# APPLICATION FOR PERMIT TO ERECT SIGN OVER PUBLIC SIDEWALK OR STREET

601 Washington Avenue--Erection of projecting signs for Gulf Oil Corp. by  
United Neon Display

Subject: Permit for construction of Ser-  
vice Station at 797-803 Washington Ave.

Subject: Permit for construction of Service  
Station building at 797-803 Washington  
Avenue

Attached please find print of Gulf Disc Sign as located at  
Washington & Ocean Aves., Portland.

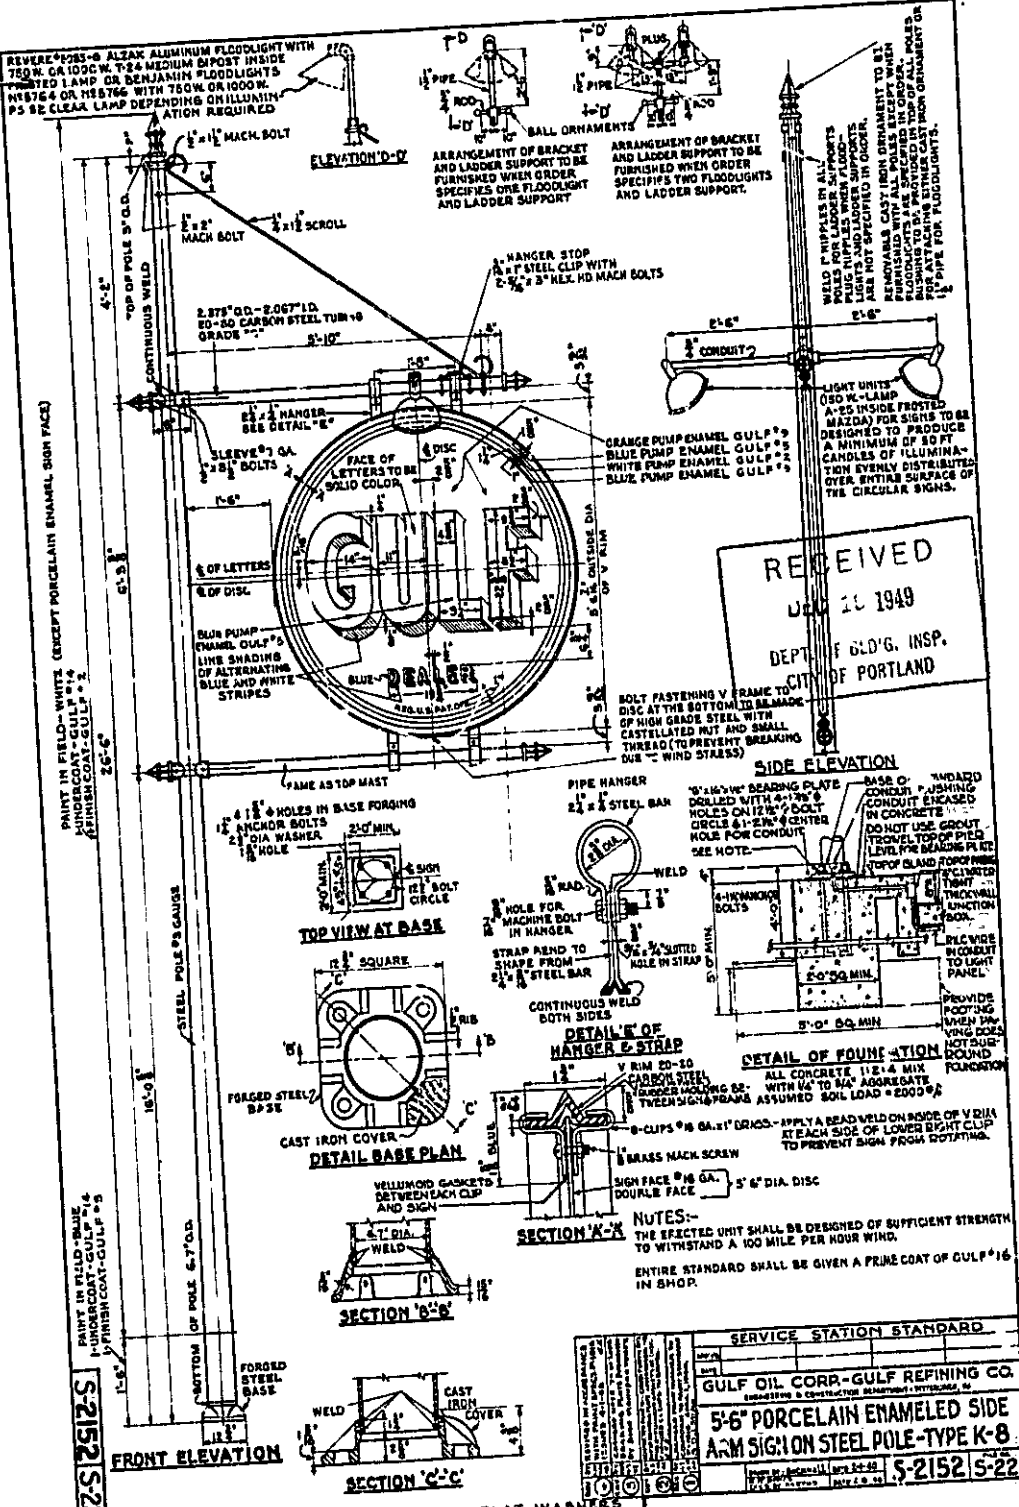
Projection of the outside edge of circular sign from the street line (inside edge of public sidewalk) must not exceed 6'. If it should, the sign would be in violation of Section 211c7 of the Building Code since the top of the sign and the upper horizontal arm will be more than 17' above the sidewalk. The location plan filed with the application carries the notation "no part of sign to extend more than 6' over sidewalk", but this is on the original of the plan and it is quite possible that the erector has no duplicate. The standard detailed plan of the sign and mast indicates that the outside edge of disc of sign would be 7' from the mast. Thus it appears that the edge of the mast nearer the inside edge of sidewalk would have to be no less than one foot inside of that edge of sidewalk which is ordinarily the street line. Please see t. it that this feature is taken care of.

Note also that top and bottom hangers of the sign are required to be bolted to the horizontal arms by bolts through both hanger and arm.
